Rezoning Transportation Analysis

Petition Number: #2022-123

Revision Log:

Date	Description
12-28-22	First Review (TM)
1-24-23	Second Review (DR)

REZONING PLAN
RZ.01

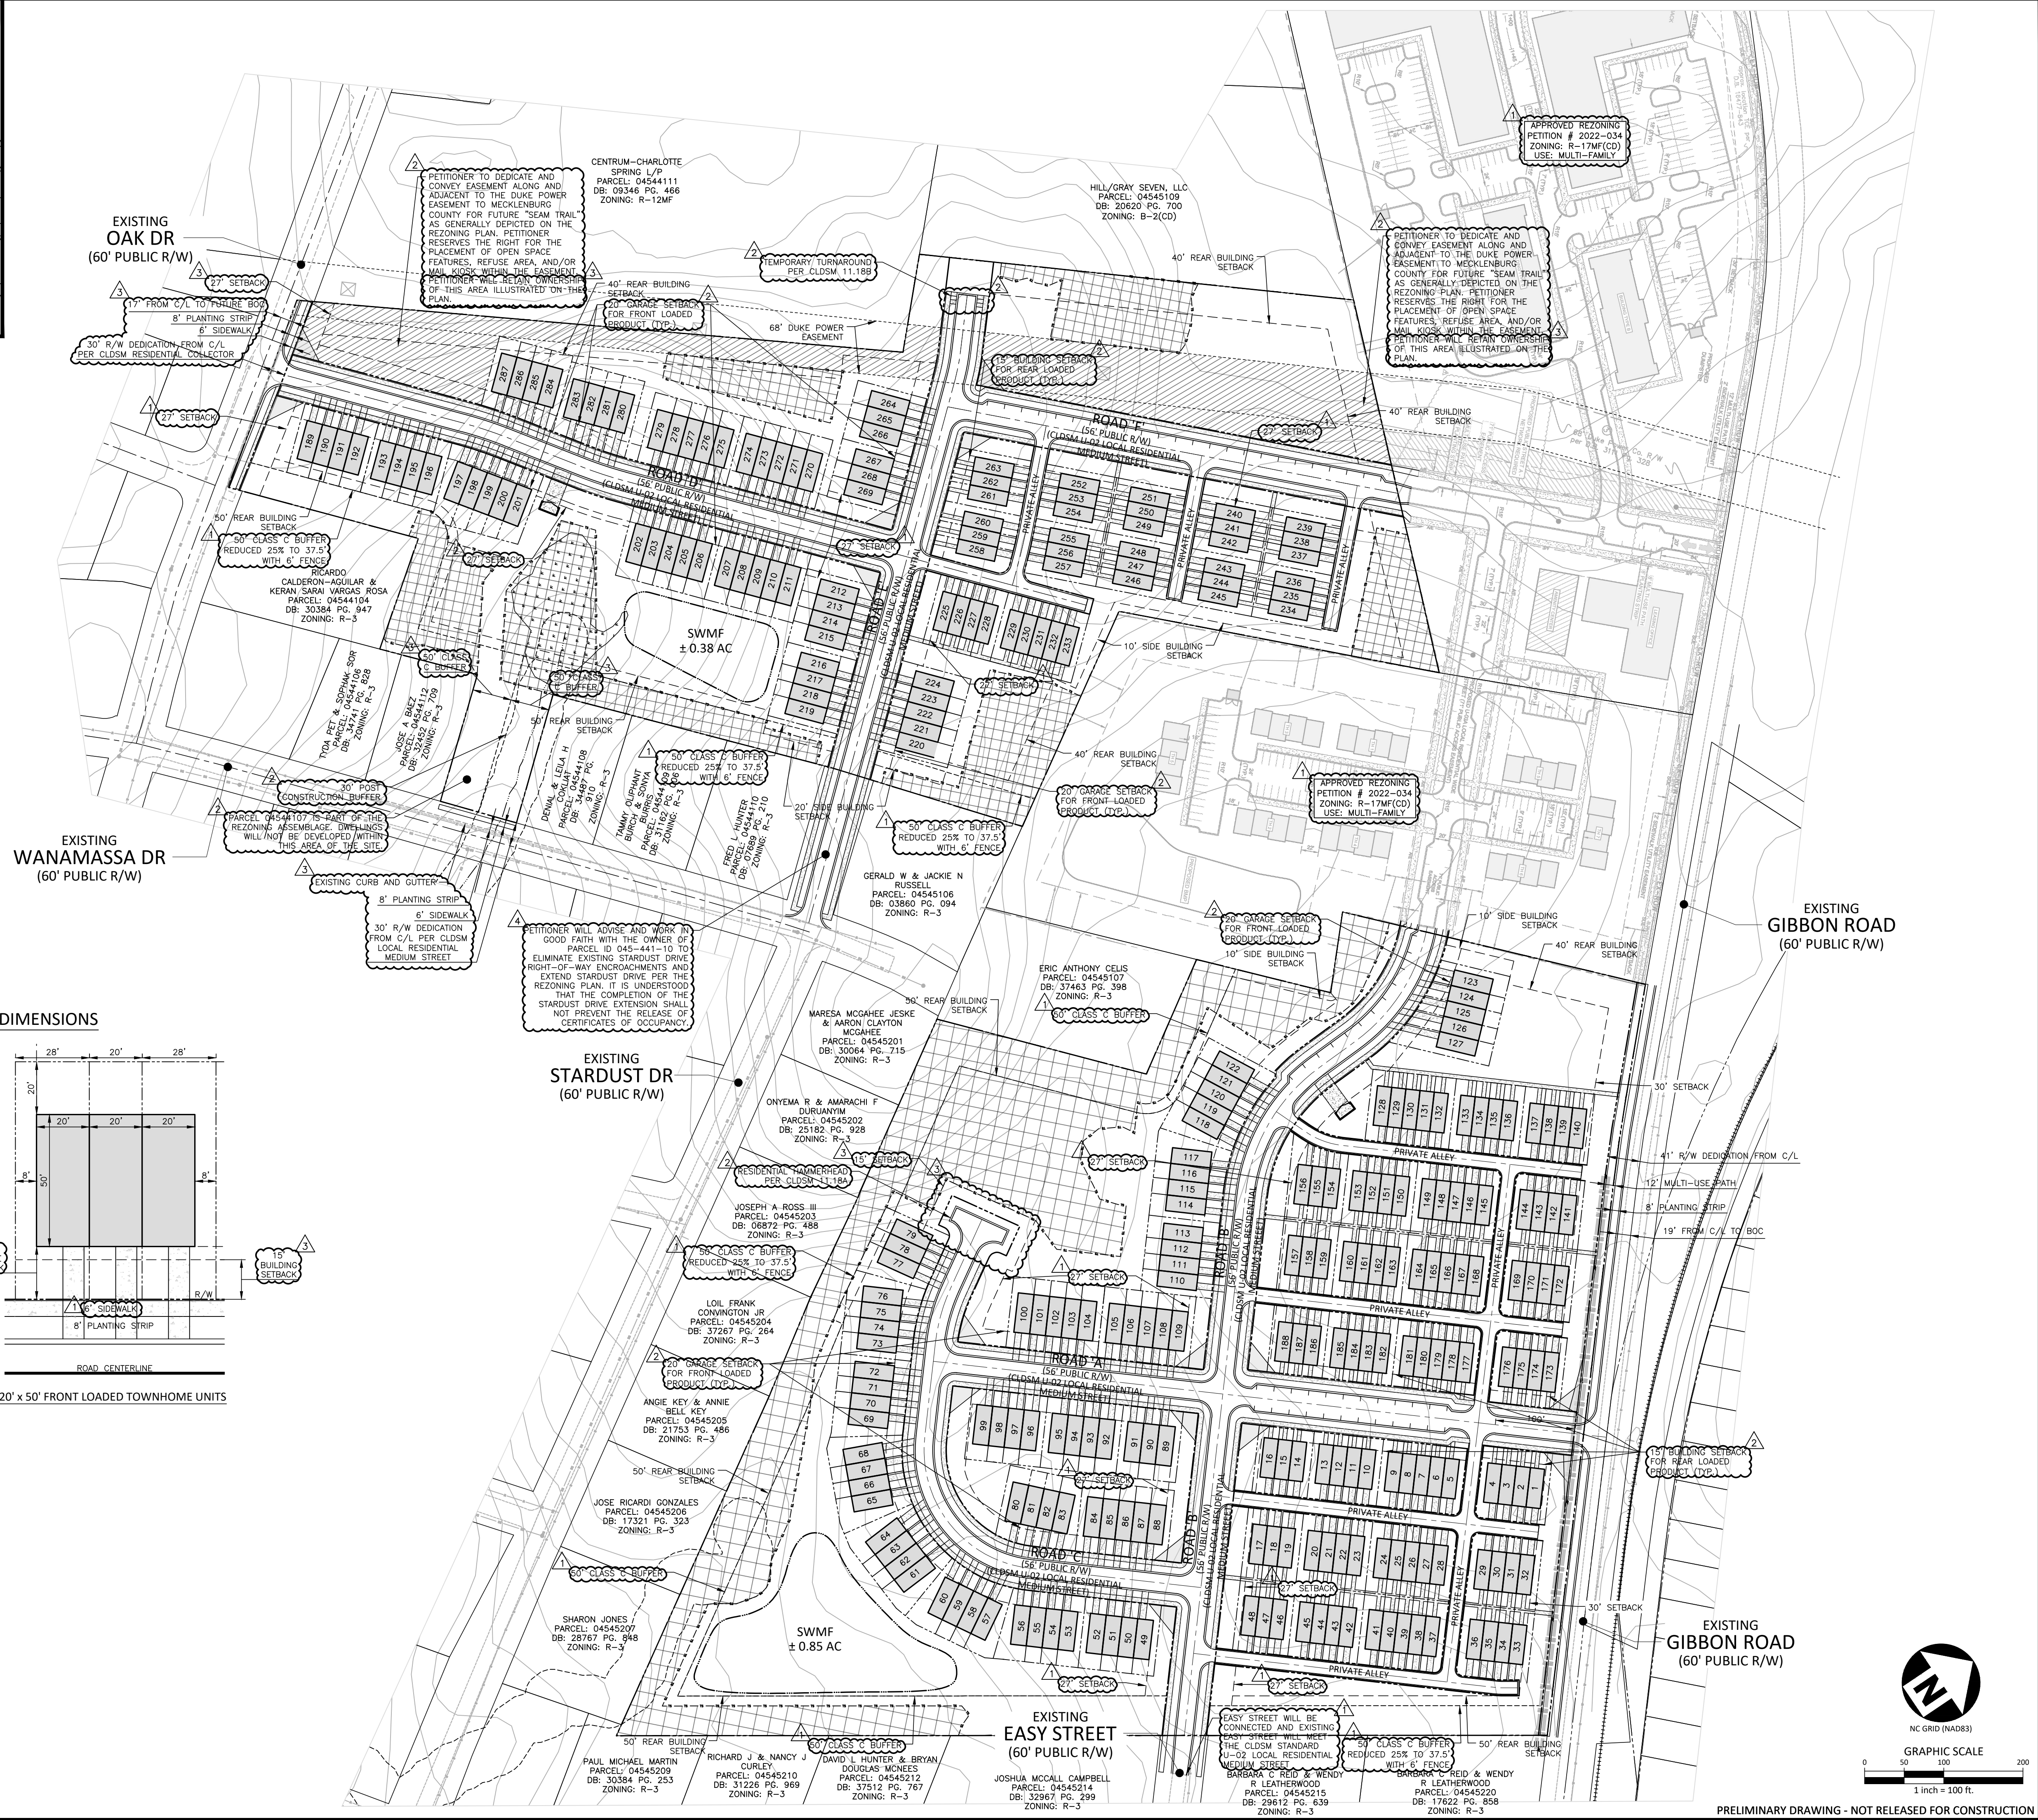
Outstanding Comment From 1-24-23: With public streets D, E, and F added. Revise conditional note to commit to construct 8-foot planting strip and 6-foot sidewalk on all internal public roadways.

- 4. **New Comment from 1-24-23:** Ensure that public road F connects to the public road A from rezoning petition 2022-034. Clearly show the connection. It is unclear from the site plan if the connection is being made.

Revise site plan and conditional note(s) to label each public roadway per CLDSM U-02 roadway typical section standards.
